From: Parish Clerk Billington and Langho Parish Council
<parishclerk@billingtonlanghopc.org>
Sent: 21 March 2024 14:38
To: Planning
Subject: 3/2024/0134

Following consultation with the members of the parish council the following request and comments were raised:-

SHEET: PROPOSED SITE PLAN

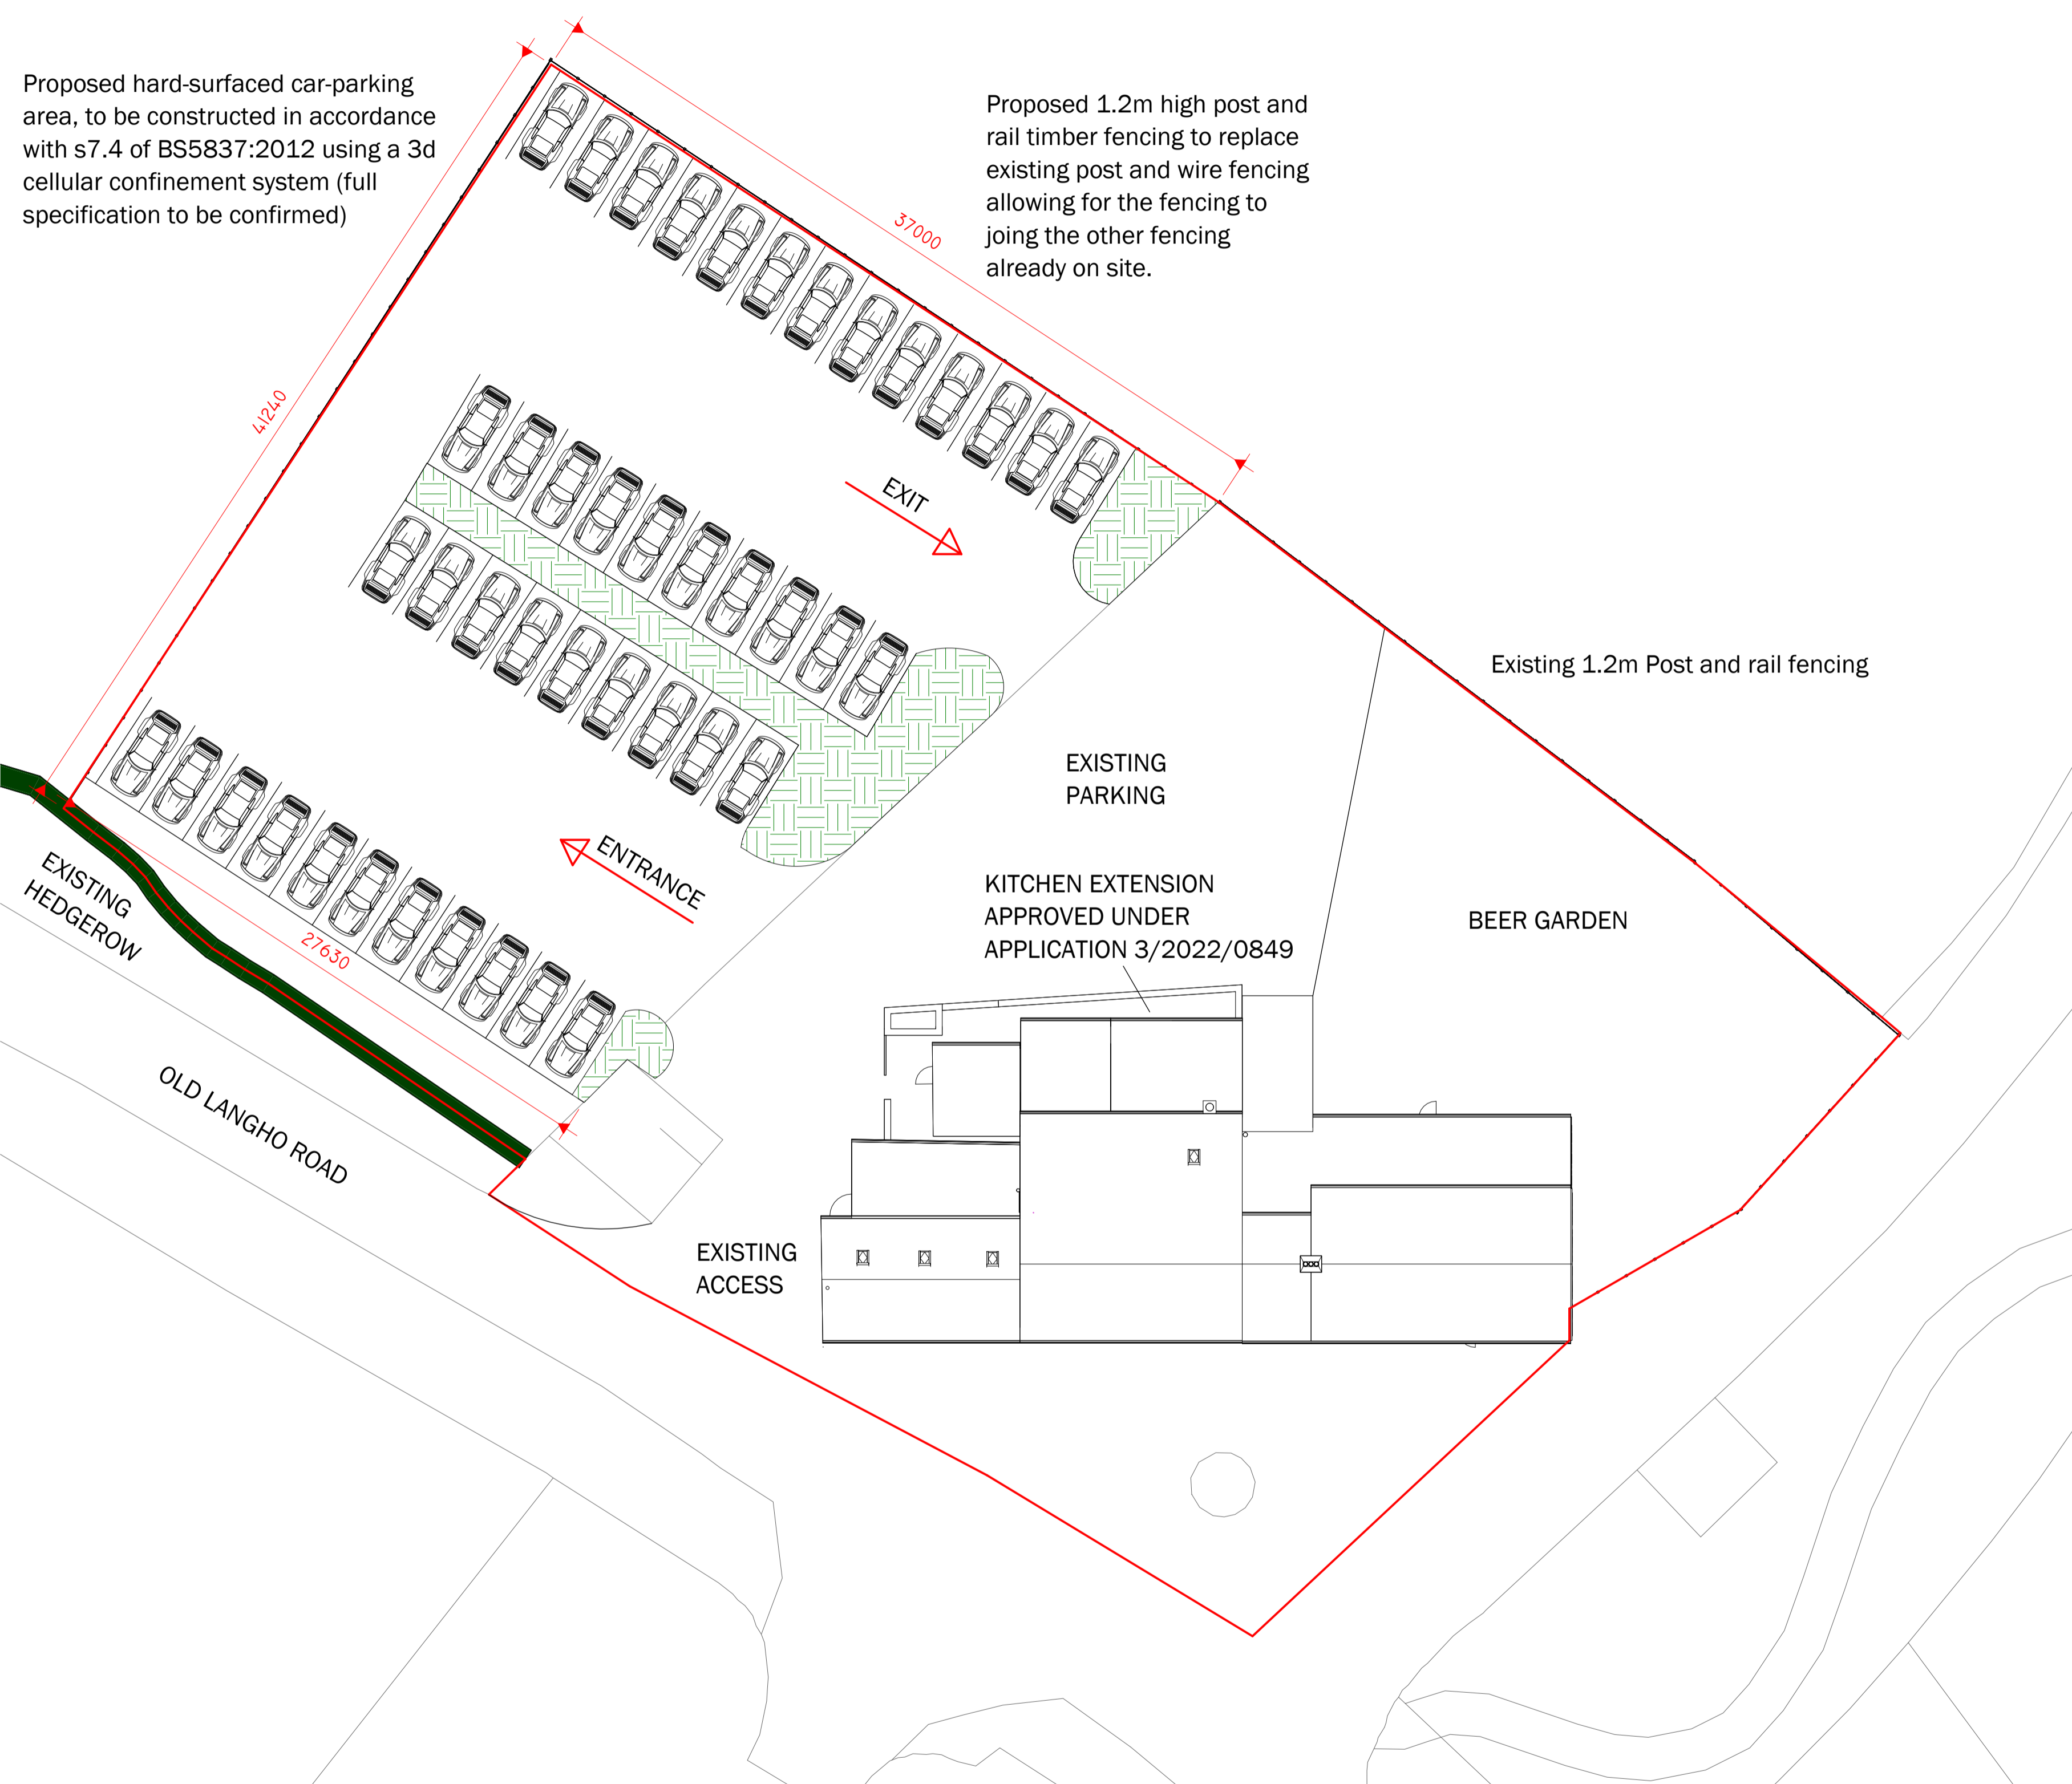
1. The PC are only supportive of a car park that is sympathetic to the surrounding countryside ie rubber matting and grass or green crete surface as it states in the application and opposed to a concrete or tarmac surface.
2. The parish council requests a condition being imposed on the car park that it can never be used for any other purpose other than a car park. Reson being that if in the future the pub was shut then the car park would be classed as brown field and could have a development of sorts on it.
